**KIRKLEES METROPOLITAN COUNCIL  
INVESTMENT & REGENERATION SERVICE**

Reference No:	<b>2024/62/92383/E</b>
Site Address:	5, Chestnut Avenue, Staincliffe, Batley, WF17 7DH
Description:	Demolition of existing garage and erection of two storey side and rear extensions and single storey front extension
Recommending Officer:	Elenya Jackson

**DECISION - REFUSED**

## **OFFICER REPORT**

PROPOSED SIDE ELEV. (SOUTH)

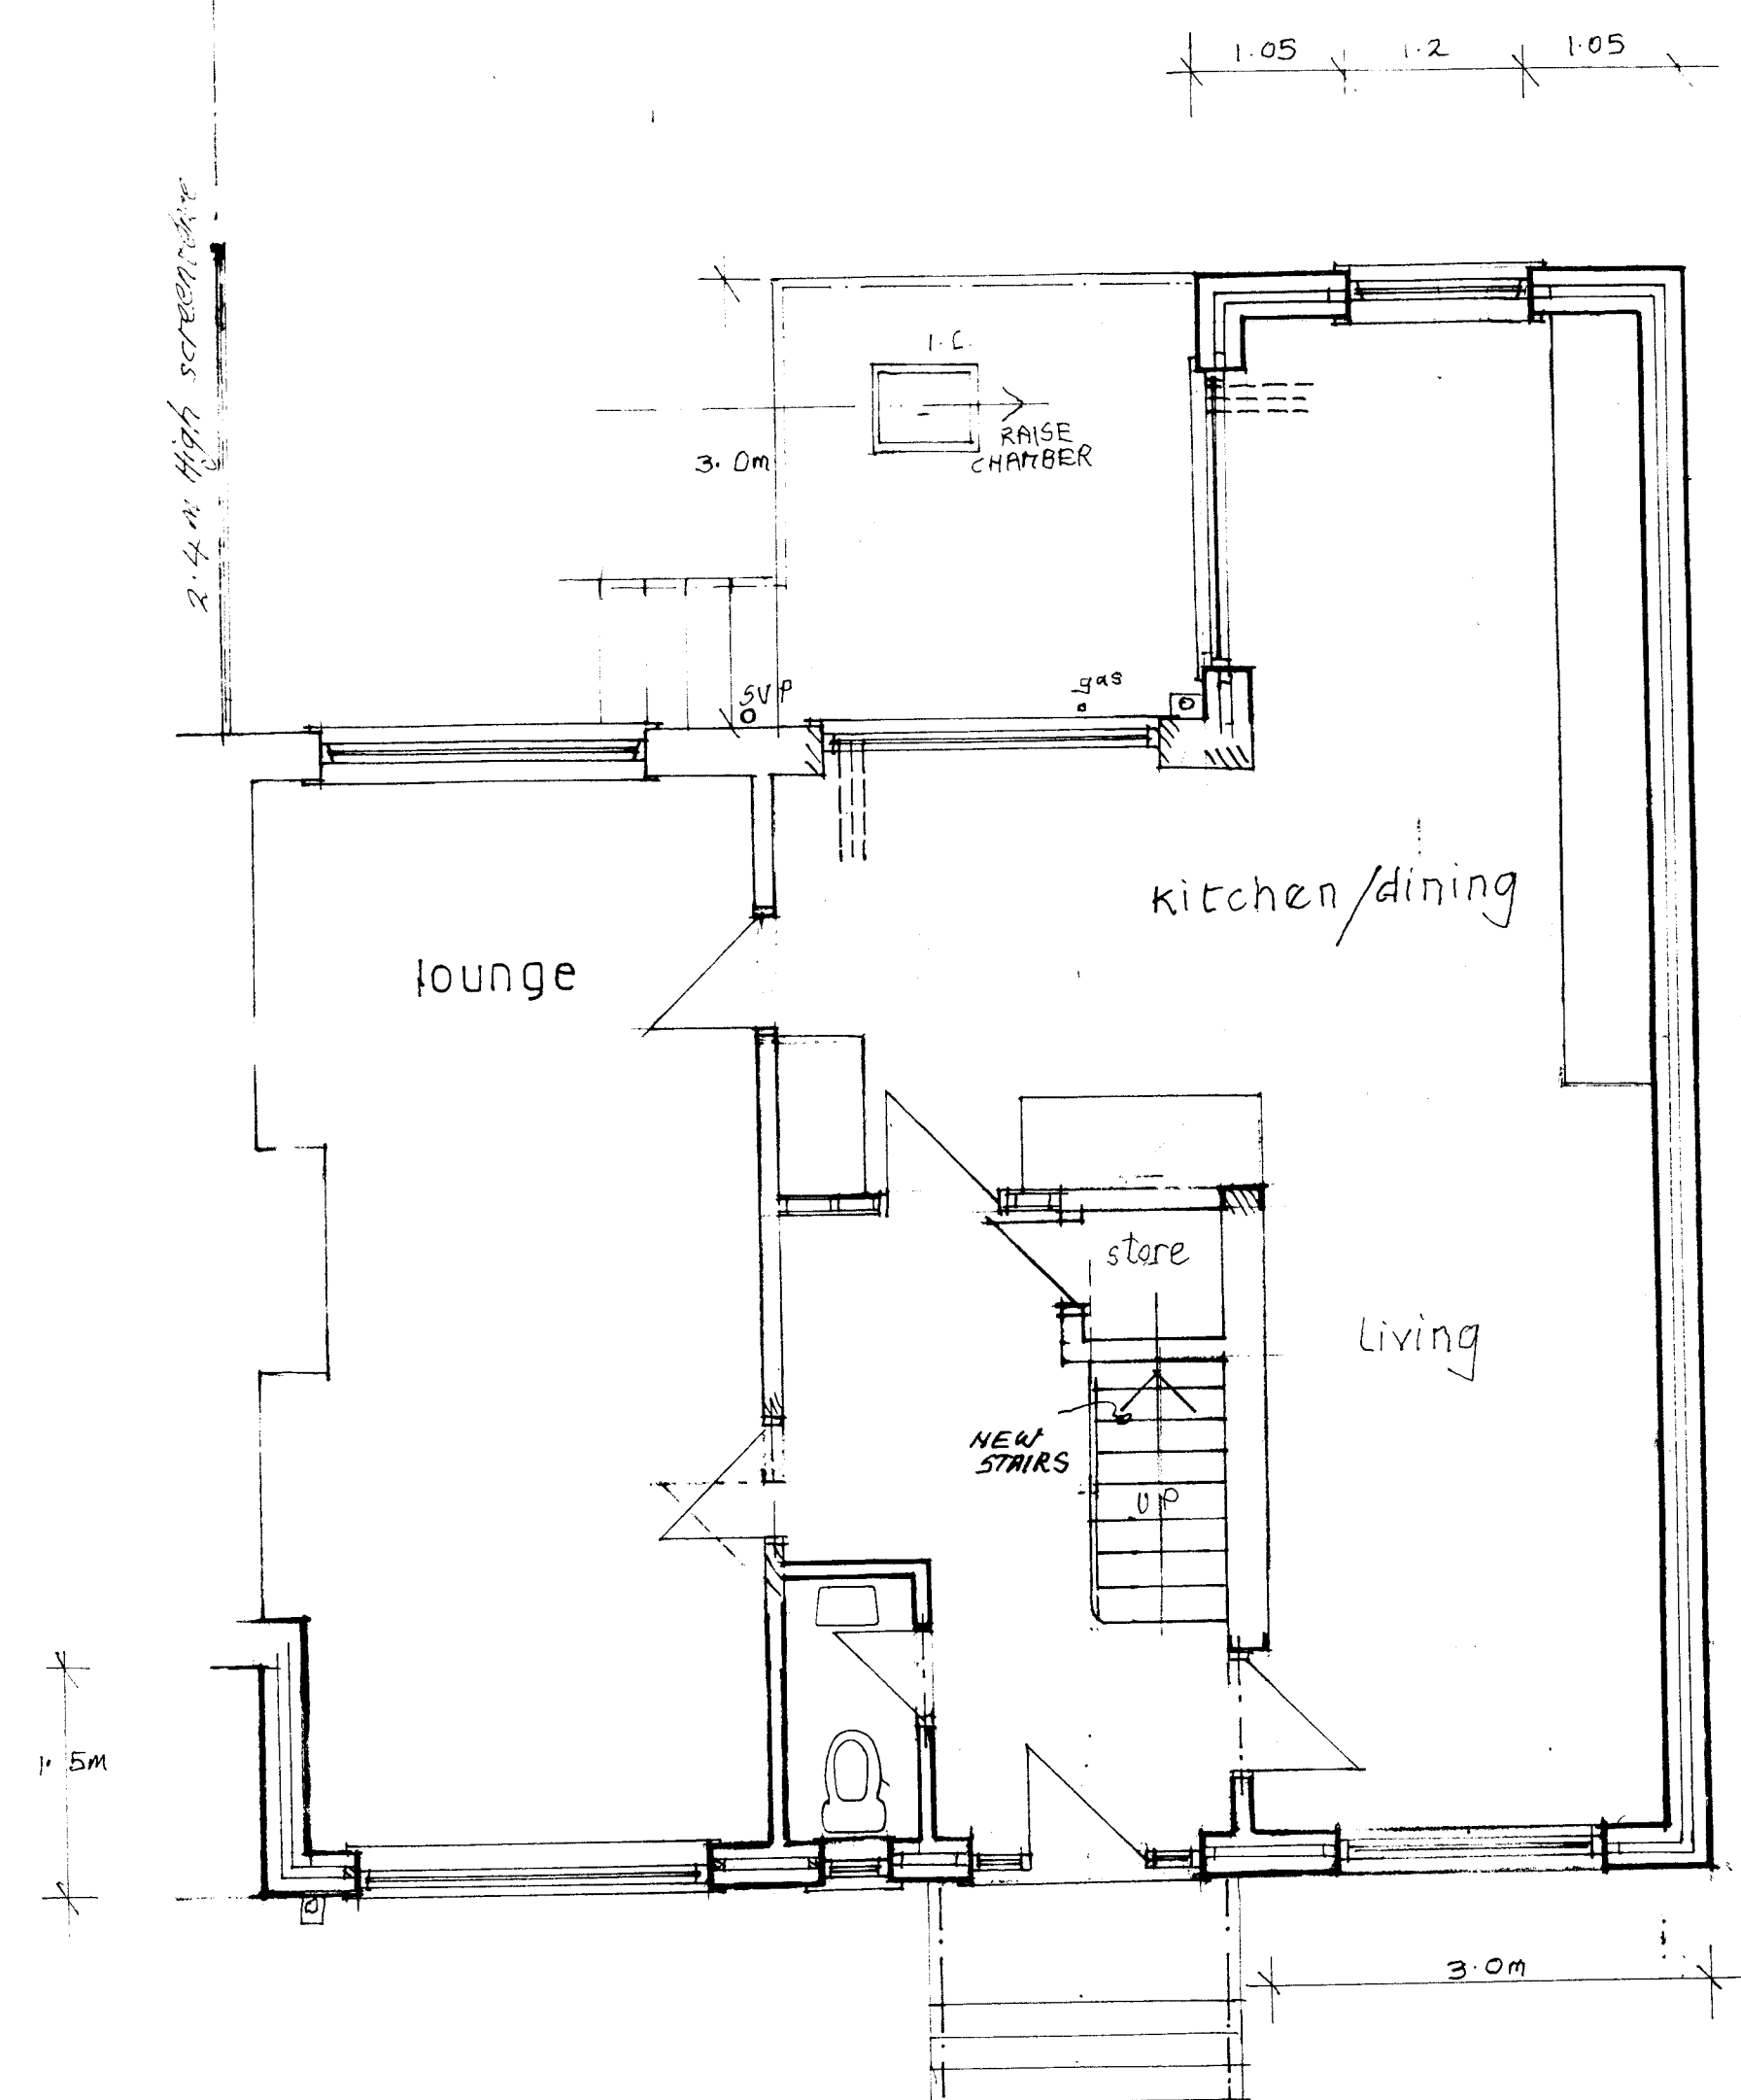
The proposed side extension would have a width of 3m, a depth of 9.4m, a maximum height of 7.7m and an eaves height of 5.8m. The proposal would not be set down and set back from the host dwelling.

The single storey front extension would project 1.6m beyond the front elevation of the dwelling with a maximum height of 3.6m and an eaves height of 3.1m.

Officers acknowledge that, the proposed extension would not be set down and back from the host dwelling and would be constructed in close proximity to the boundary of the site thereby not meeting the SPD. Officers have viewed the immediate vicinity of the site, No.3 and no.1 (a semi-detached pair) have extensions of a similar scale to the proposal.

It is considered that, the introduction of a two storey side extension would interrupt the spacing of the street scene and create an unacceptable terracing effect from no.1 to no.7 Chestnut Avenue. It is considered that the proposed two storey extension would therefore fail to respect the character of the street scene or prevailing character of the area.

Overshadowing/loss of light/overbearing: There is one side facing window which relates to the living room of no.3. The proposal would introduce a two storey blank elevation parallel to a single aspect ground floor living space. It is considered that this would result in an unacceptable impact on the living conditions of current and future occupiers of this property.

1. The proposed extension, by virtue of its scale, massing and close proximity to a shared boundary, would result in an overbearing and overshadowing impact to the side facing living room window at 3 Chestnut Avenue detrimentally impacting on the residential amenity of current and future occupiers of this property. To permit this development would be contrary to Policy LP24 of the Kirklees Local Plan, KDP1 & KDP2 of the House Extensions and Alterations SPD and advice within Chapter 12 of the National Planning Policy Framework.

1. The two storey side extension proposed would take up most of the space to the side of the house coupled with the the lack of set down and back would result in an unacceptable terracing effect. As such it would close a gap between the houses eroding the sense of space between houses which is a positive characteristic of the street scene. This does not promote good design and is contrary to LP24 of the Kirklees Local Plan and design guidance given in sections 4.1, 4.2, 4.3, 5.19, 5.20 & 5.21 of the Kirklees House Extensions Supplementary Planning Document.
